FLYING HORSE NORTH FILING NO. 9 CONSTRUCTION DRAWINGS

CONSTRUCTION DRAWINGS
COVER

SF2625

TYPICAL URBAN LOCAL CROSS SECTION

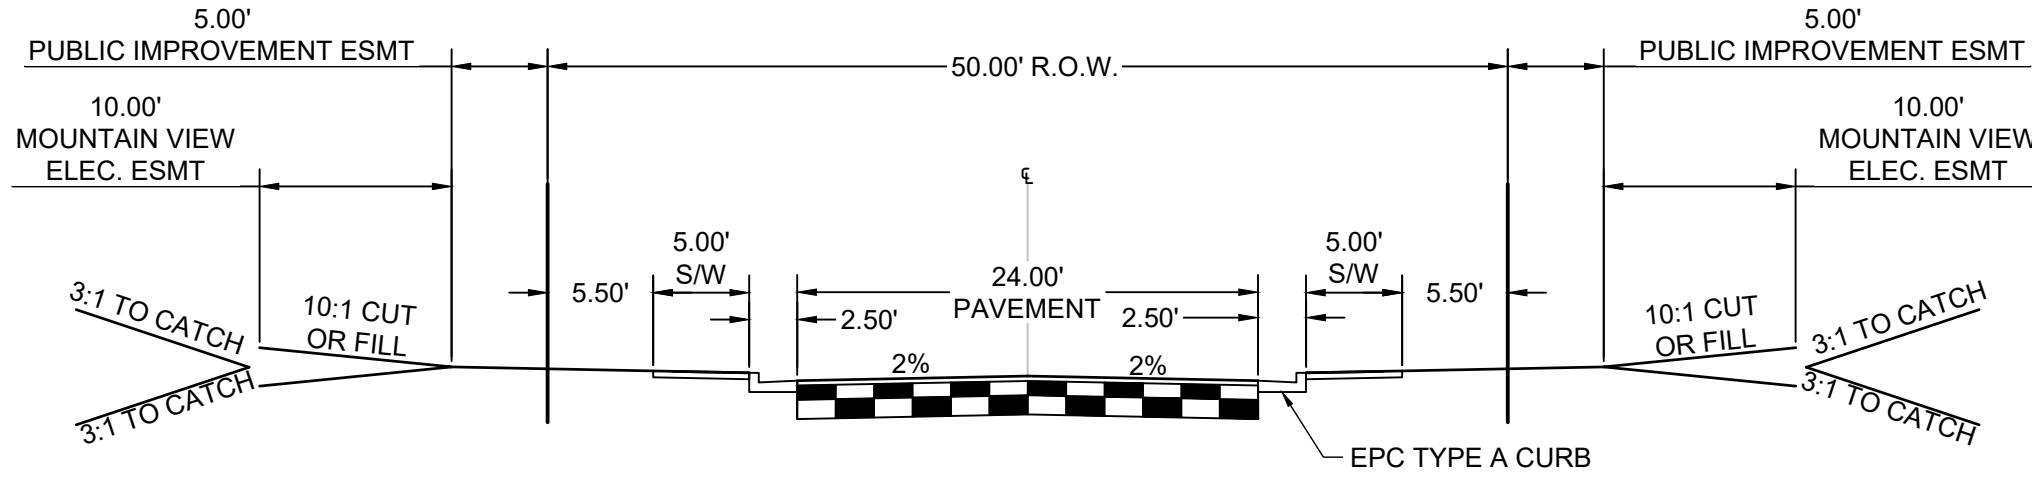
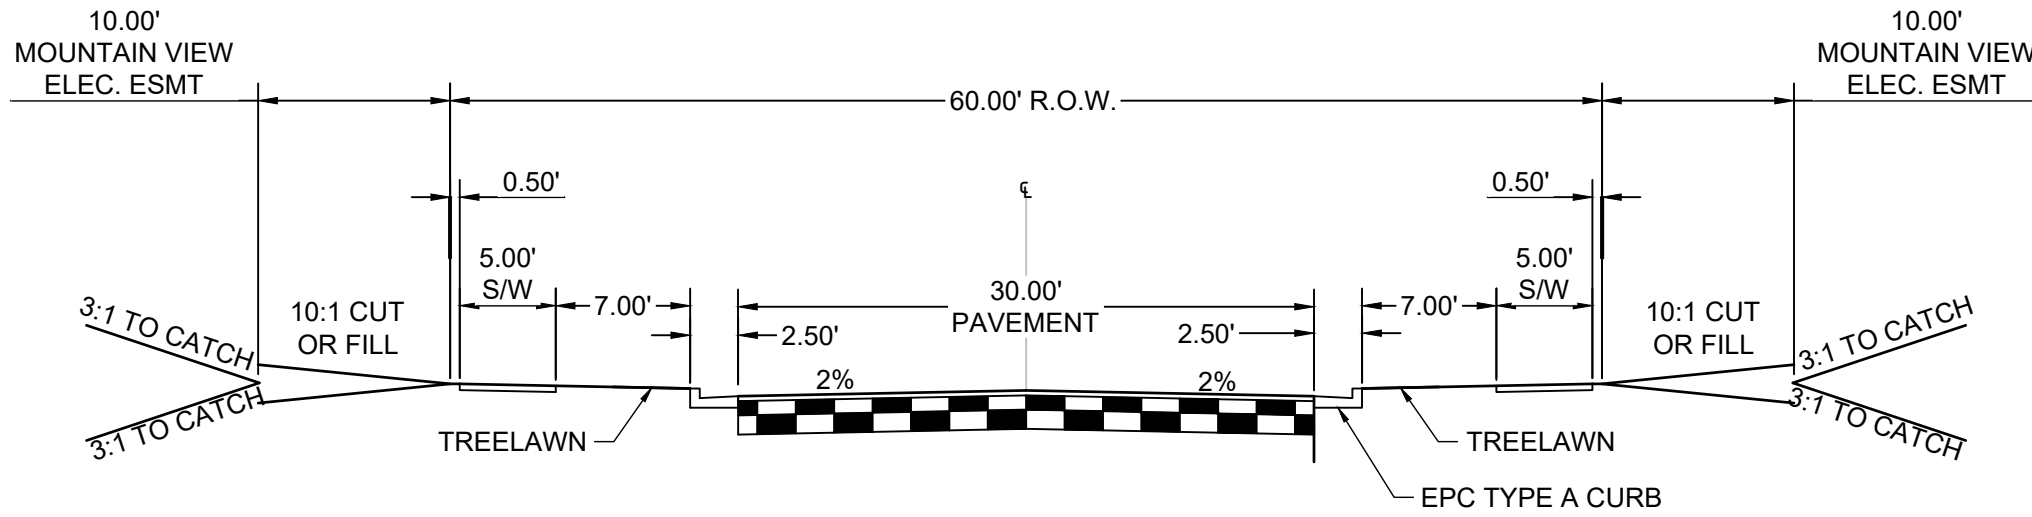
Where is this road section being proposed? It appears that Sorraia Way / Ace Way follows the typical urban local cross section above.

SIGNAGE LEGEND:

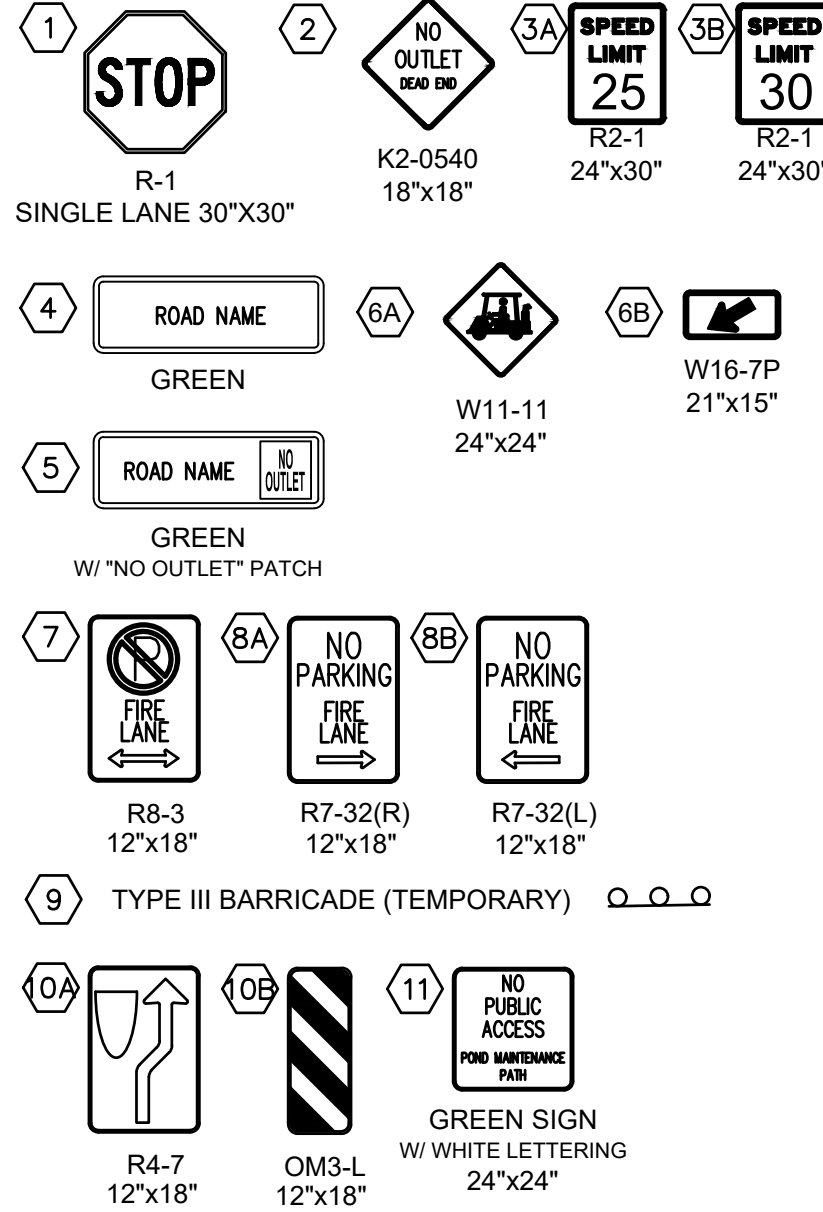
min 24x24

min 12x36

Min size is 18x24
